**Modification to the Teys Australia Beef Abattoir (DA220-07-2002-I-Mod-12)
Request for additional information**

Attachment 1: Request for additional information

Request for additional information

35A301 - 16

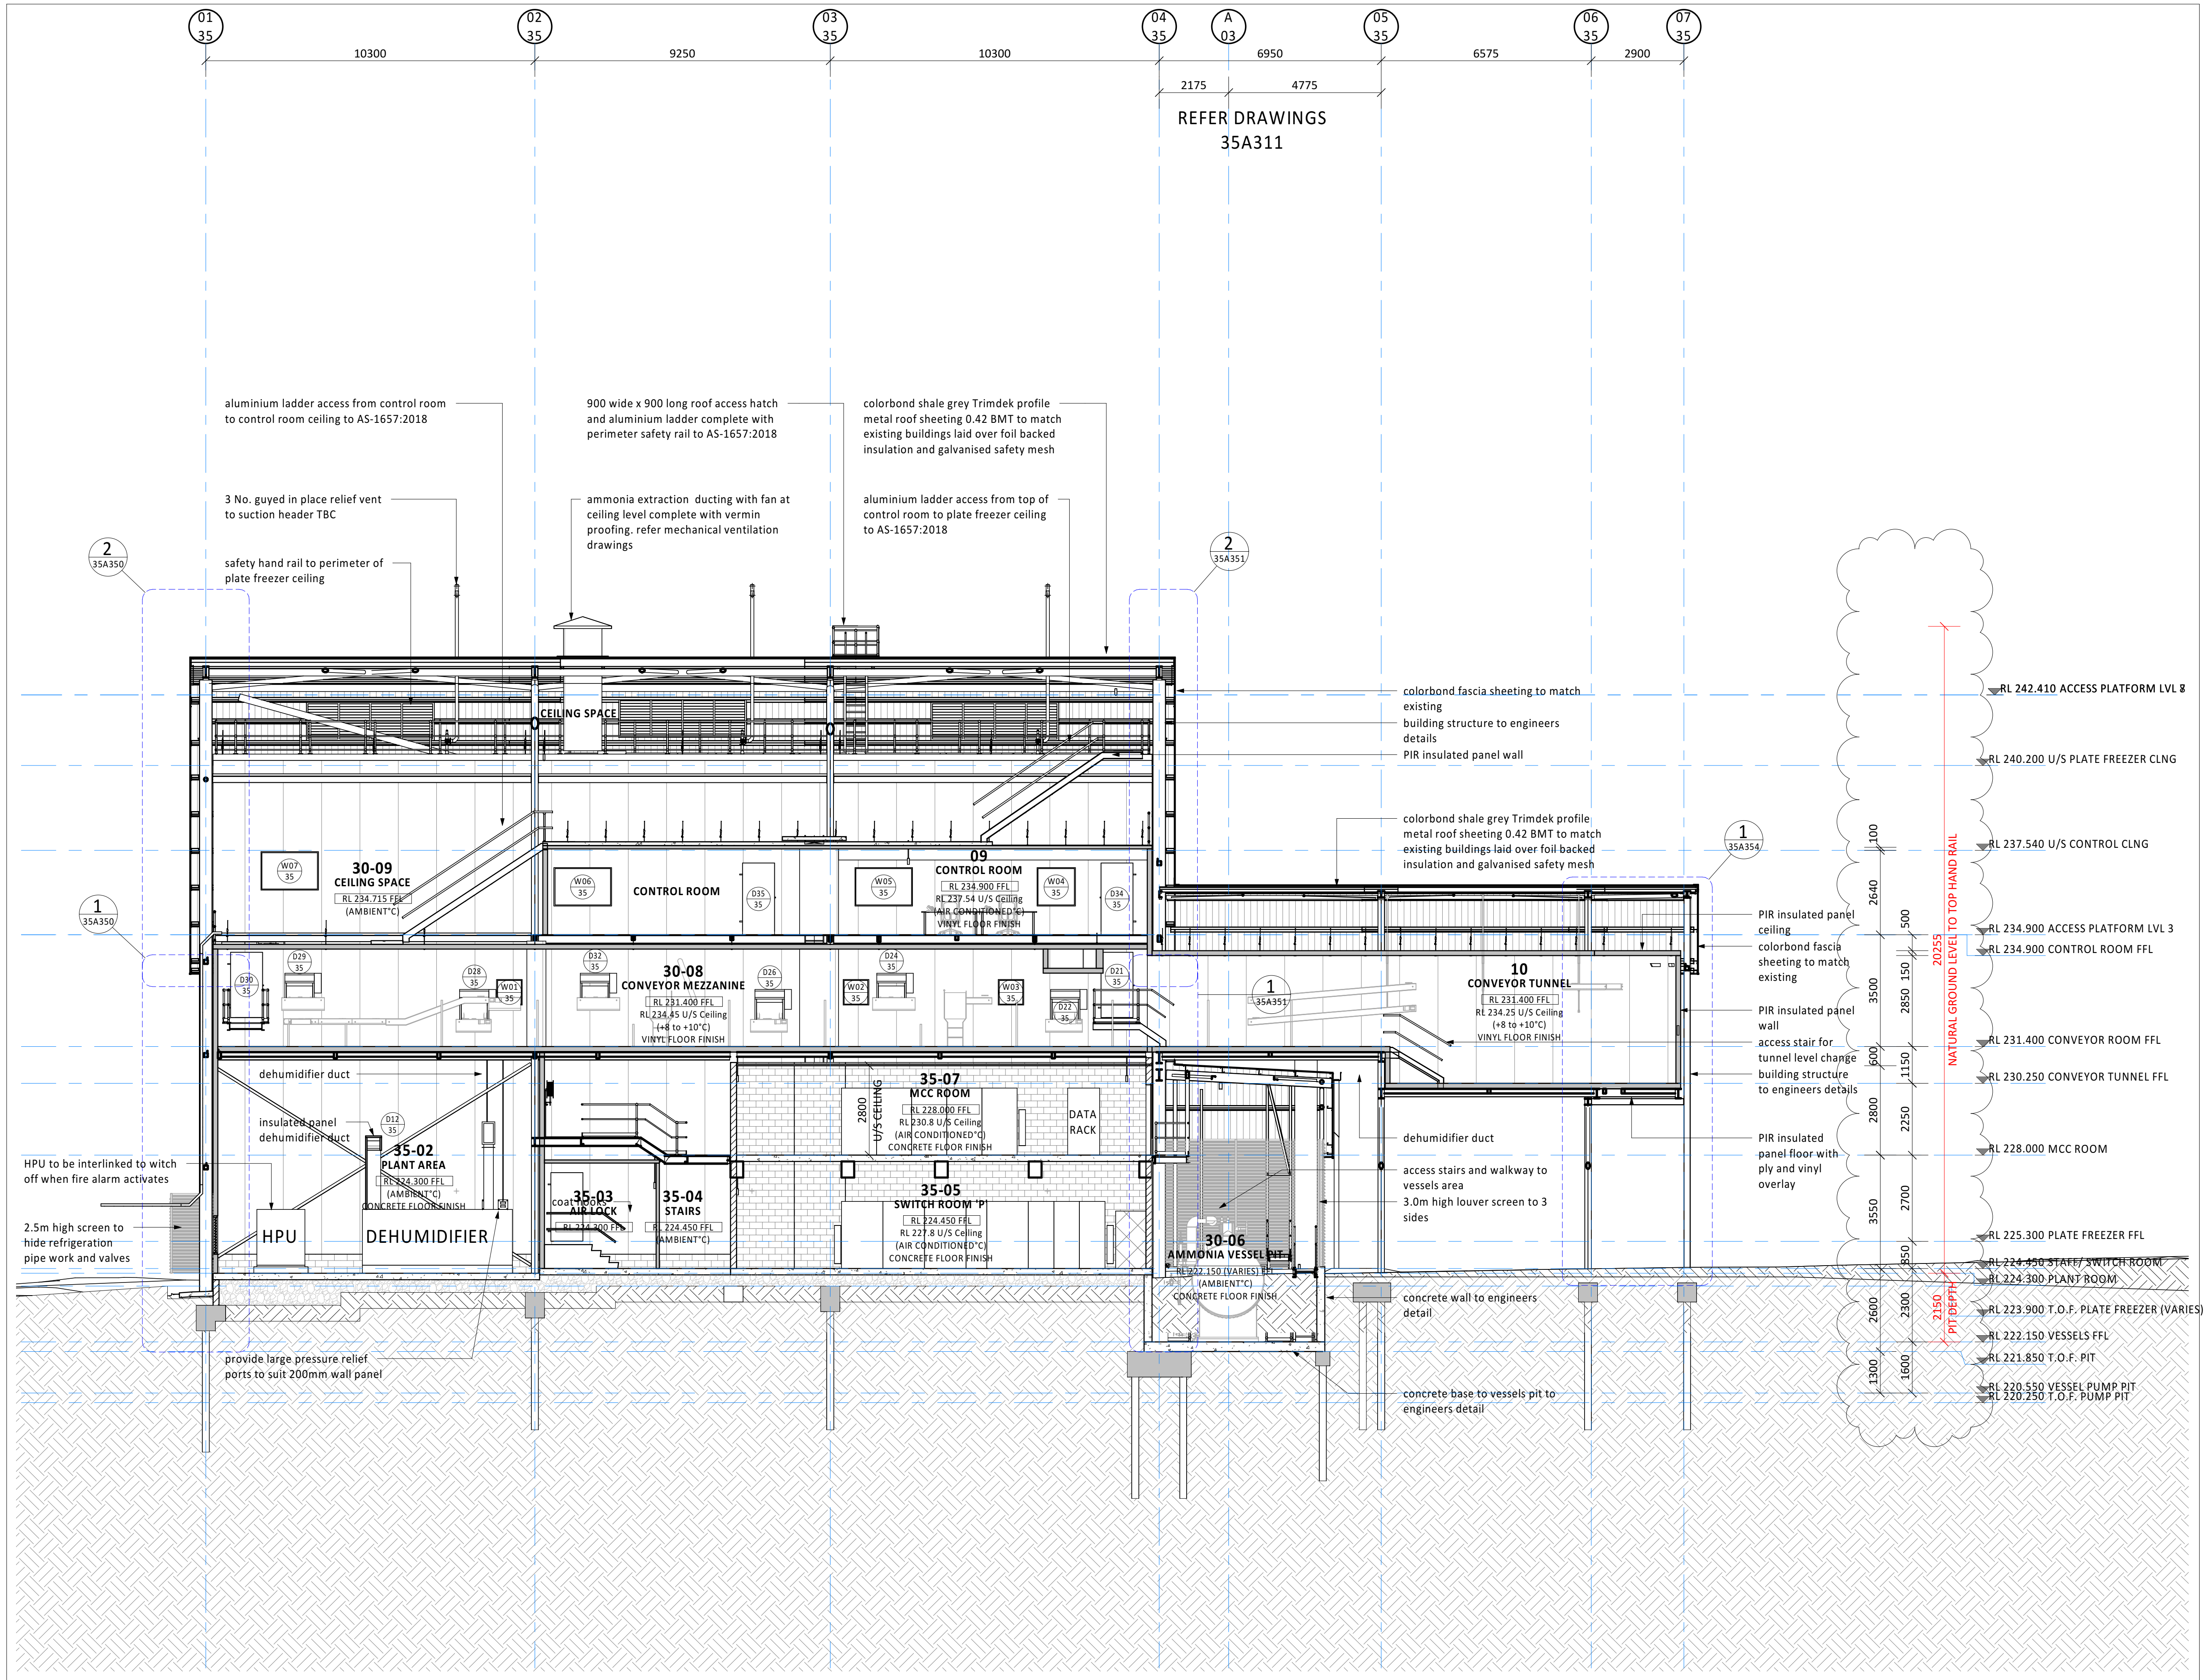
- No reference is made in the Report as to the excavation required to facilitate the "ammonia vessel" footprint as demonstrated in section plans No. 35A301.8 & 35A302.1. The excavation is demonstrated at up to 3.75m below the ground level. Further details on the proposed excavation and information referencing the provisions of State Environmental Planning Policy No 55 – Remediation of Land (SEPP 55) is to be provided.

00A210 - 1
NOT FOR CONSTRUCTION

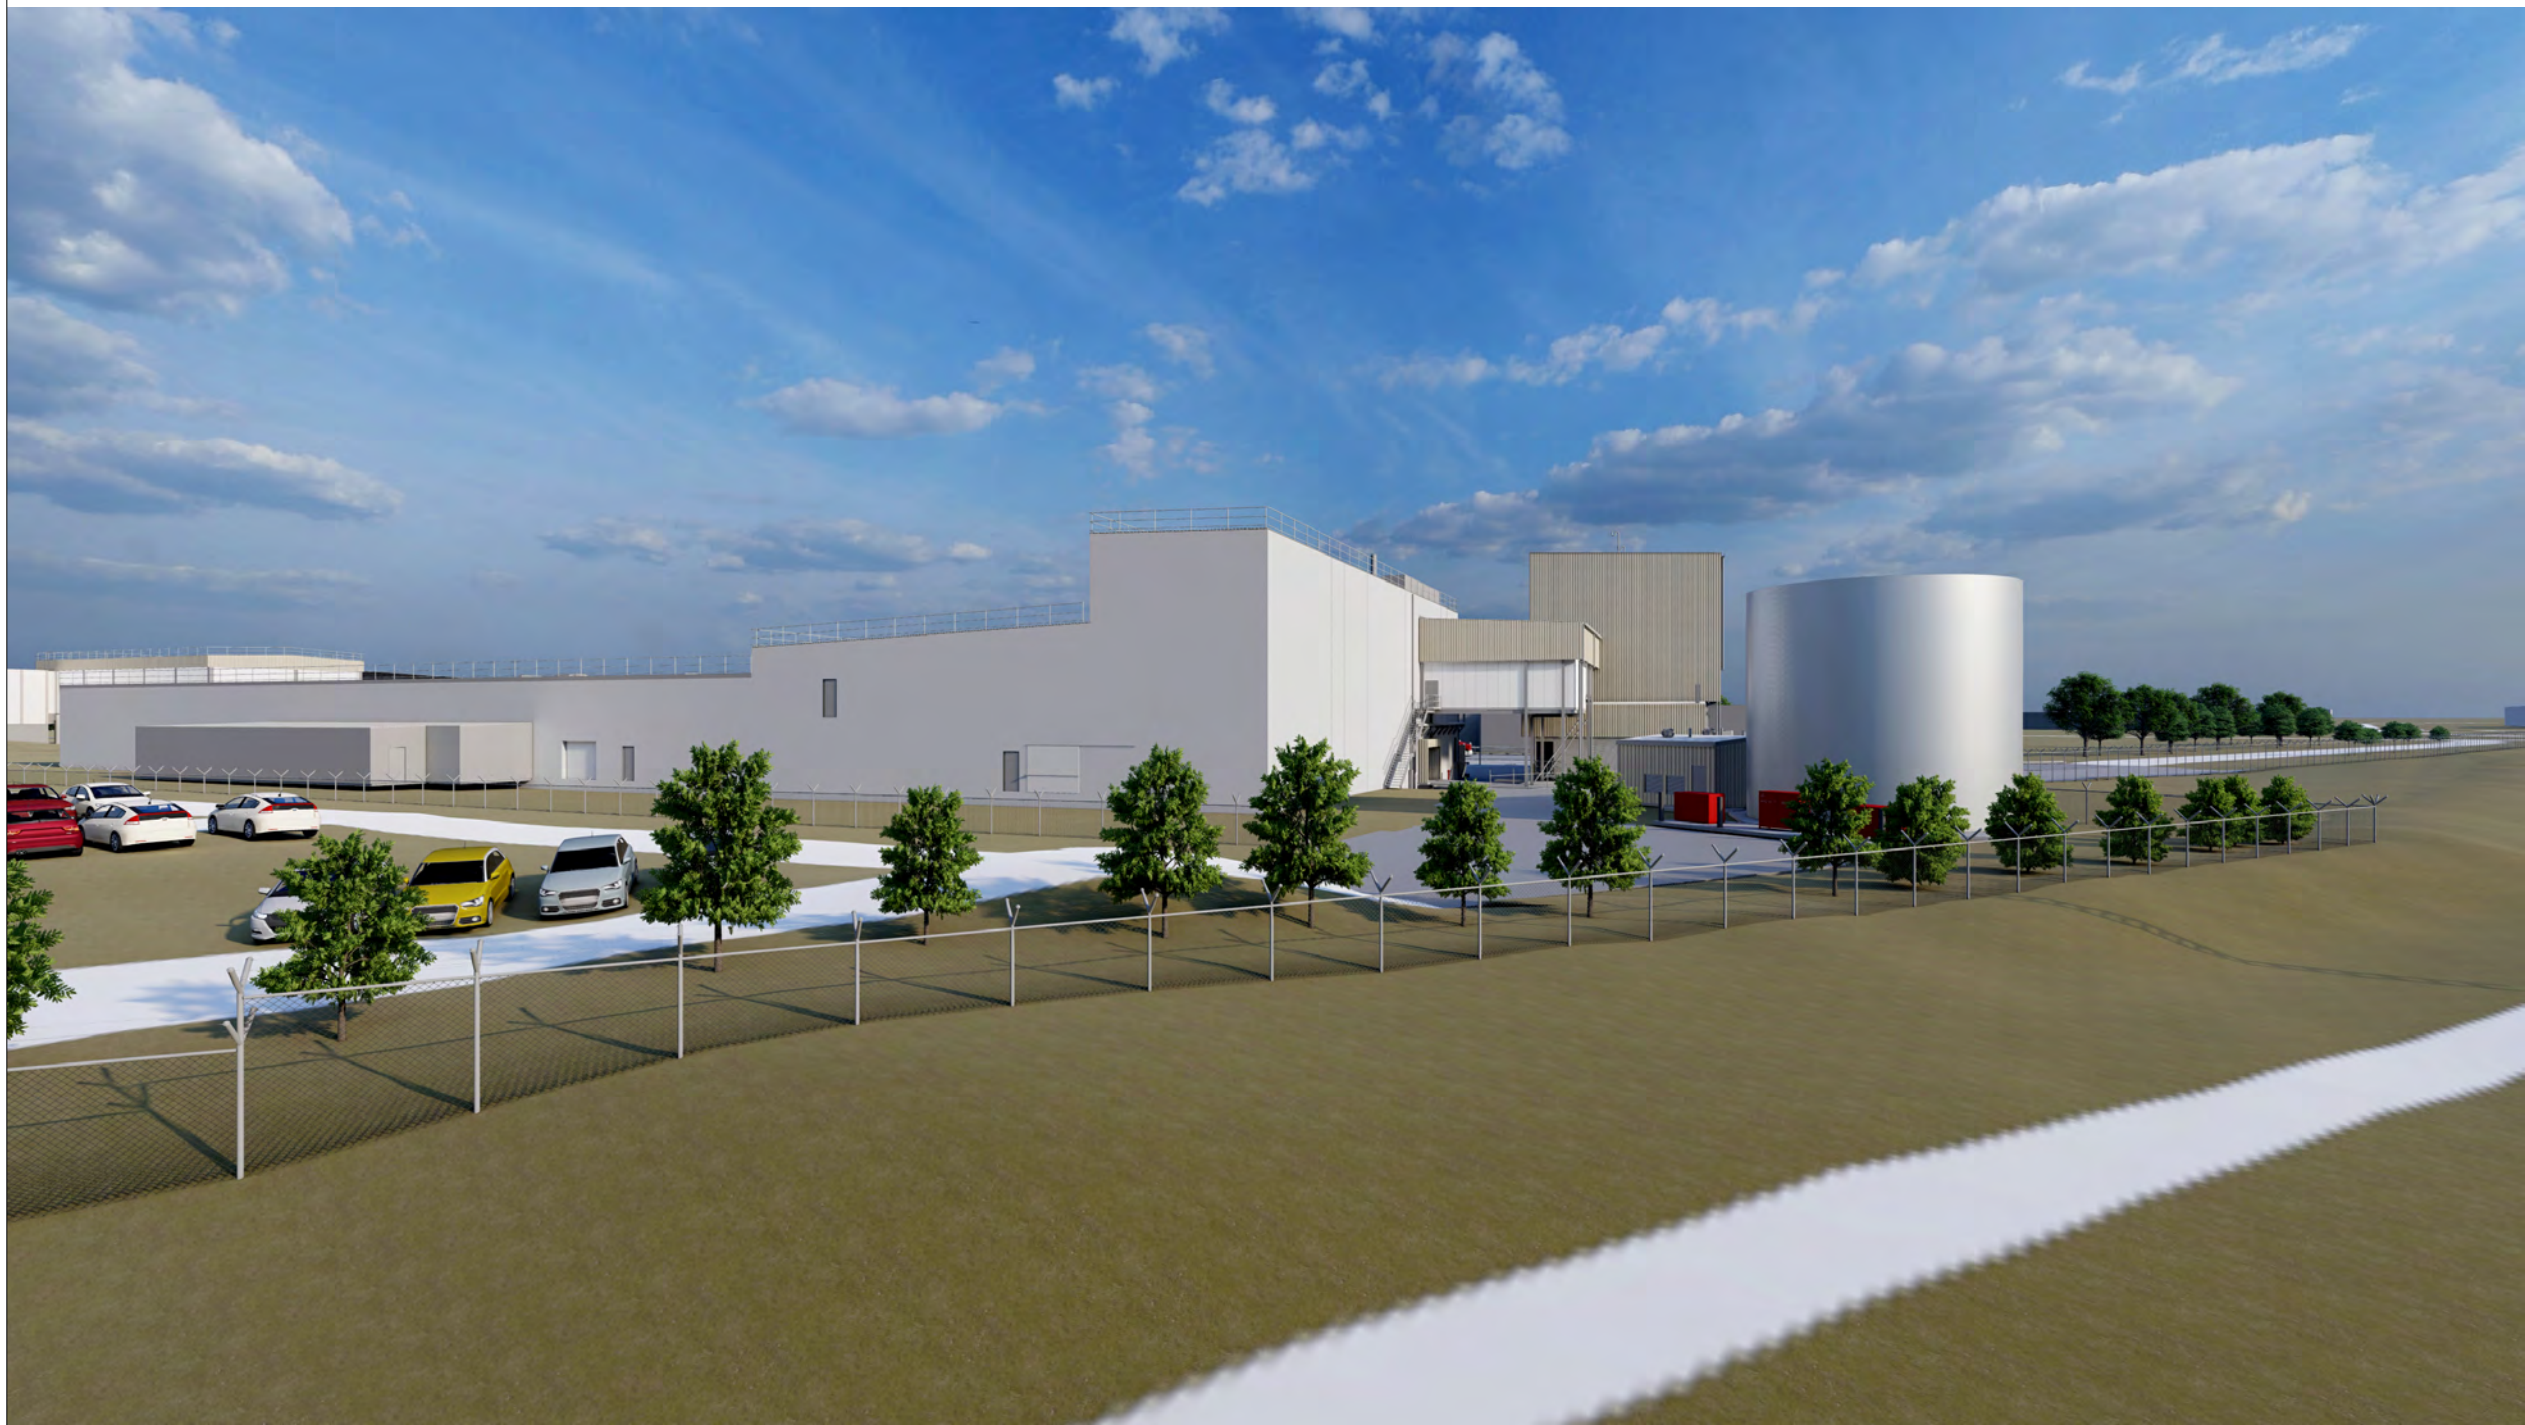
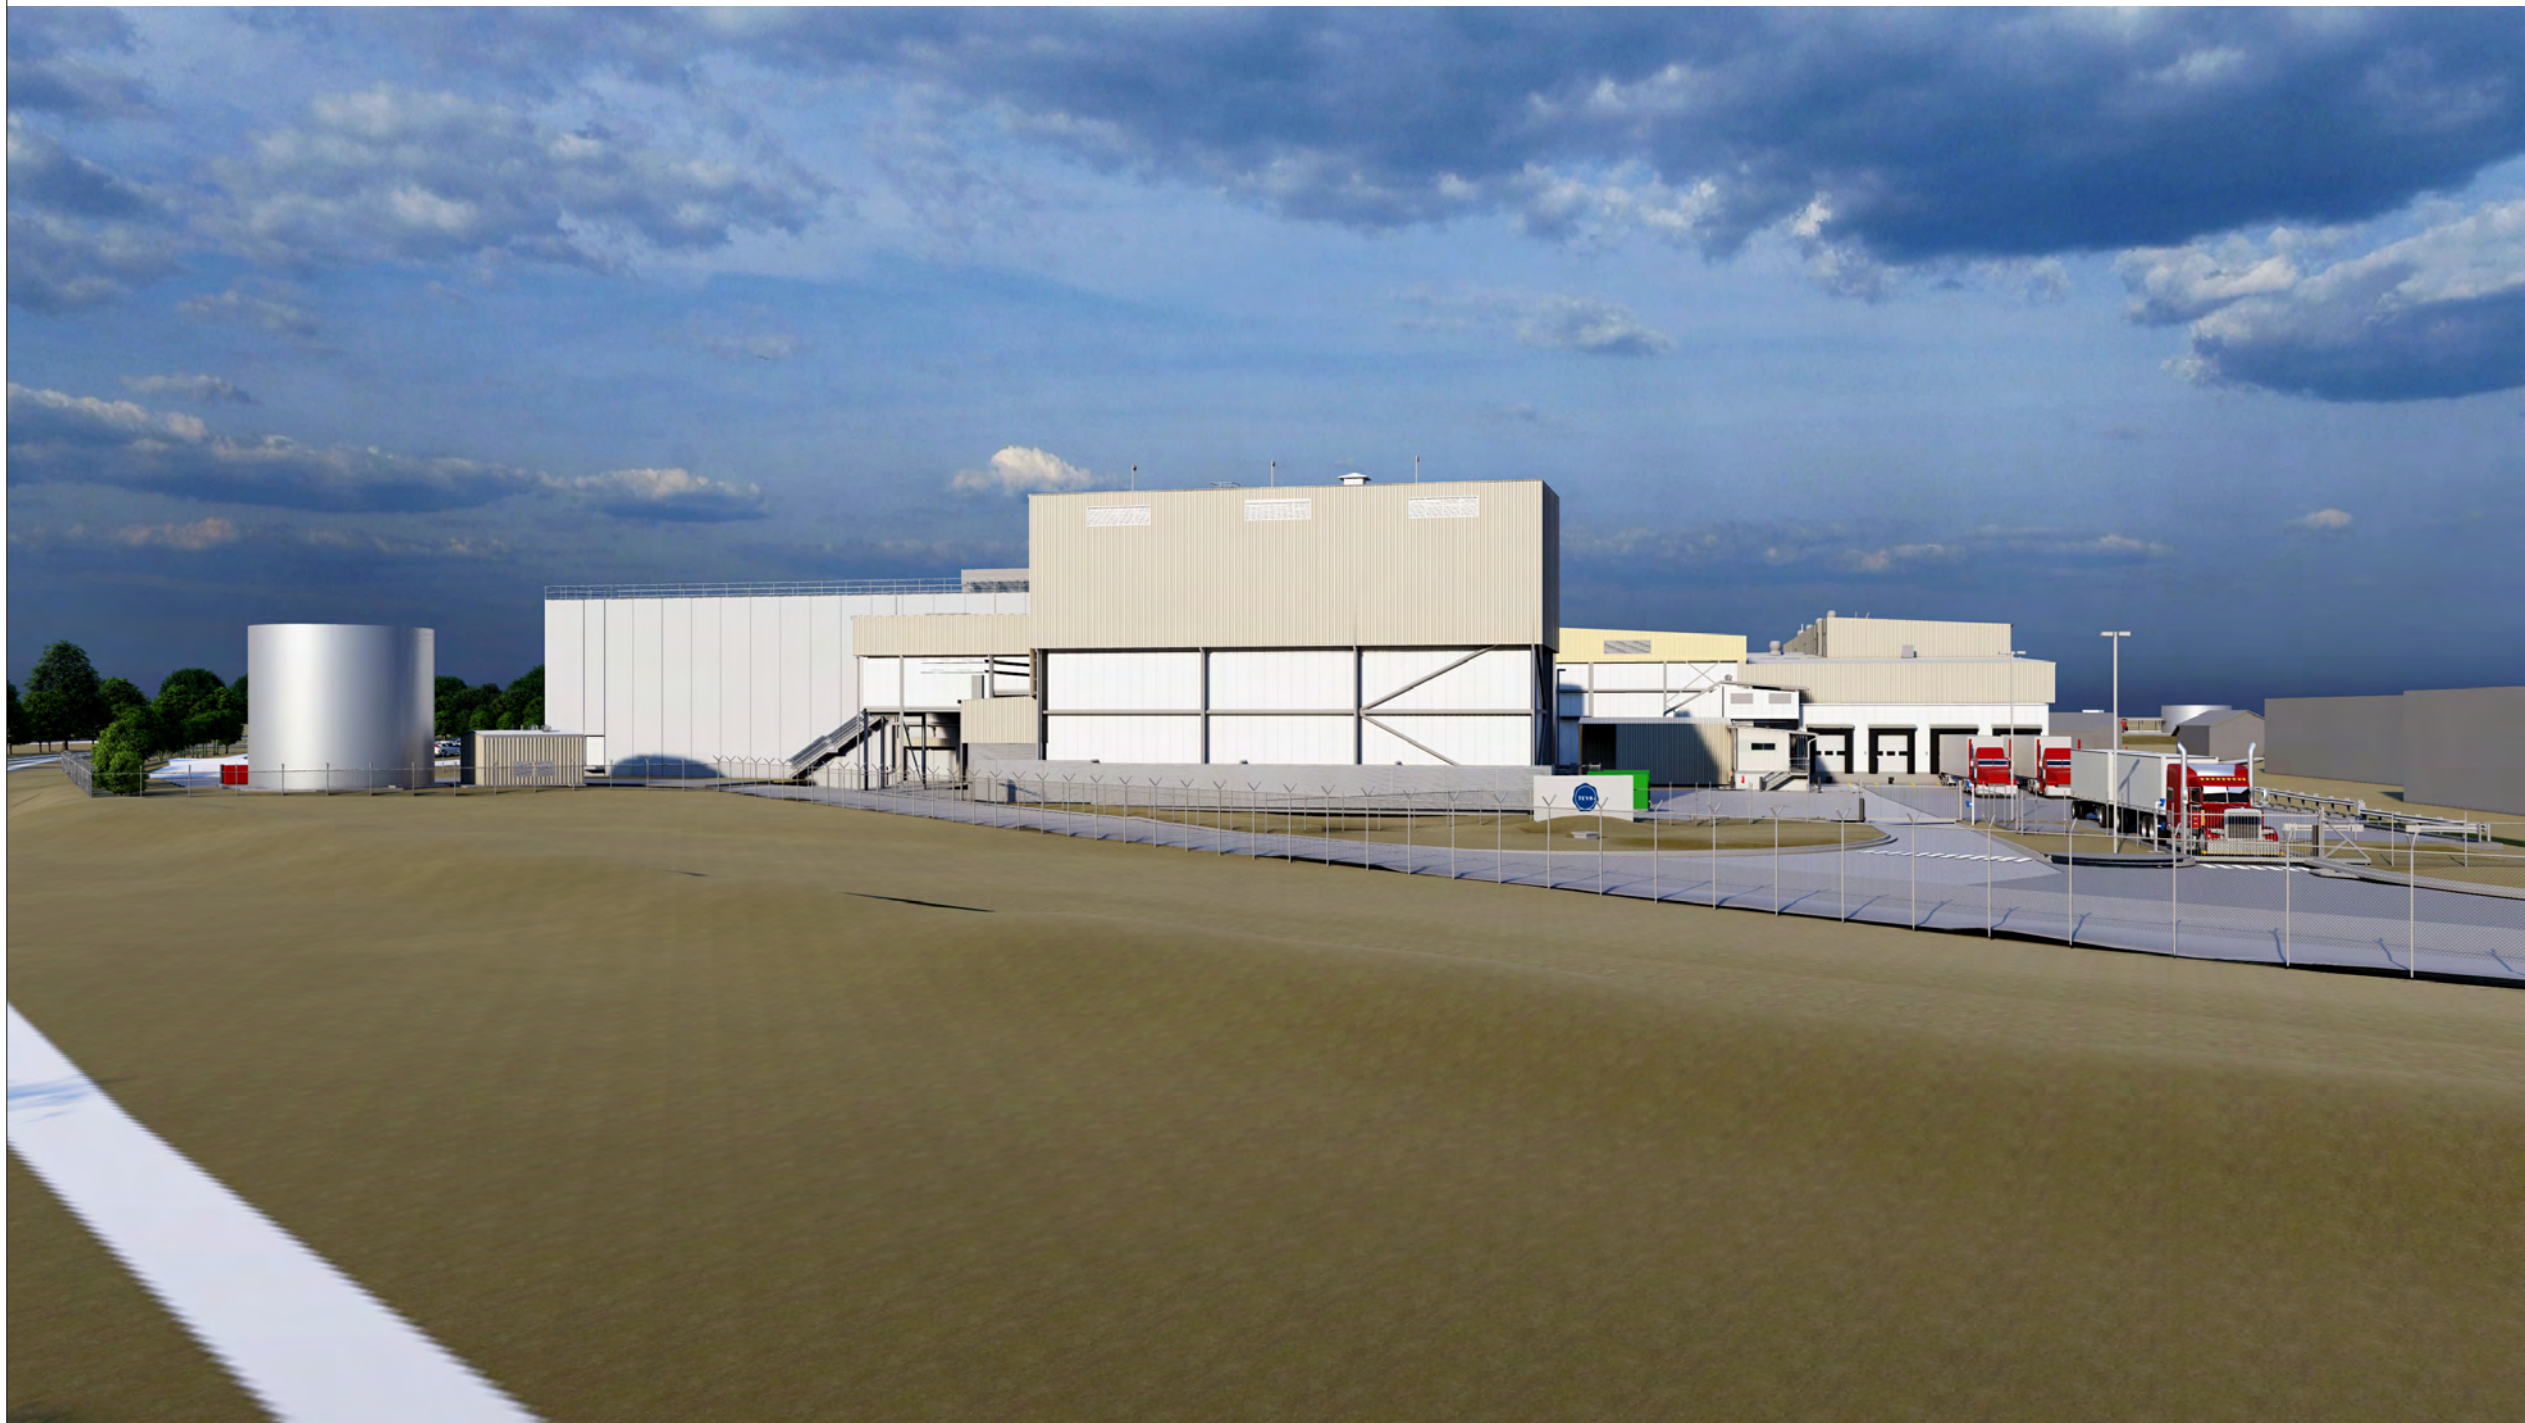
- Please clarify the capacity of the ammonia storage vessel.
- The proposed works include the construction of two buildings, with one building (Plate Freezer) over 18.5m in building height, yet the Report states "*the proposed modification will be negligible in terms of potential visual impacts derived from any additional building height, bulk or scale*". Further details should be provided to confirm the visual relationship between the proposed works and the existing buildings and, if necessary, an assessment of potential visual impacts from public vantage points (e.g. Byrnes Road).
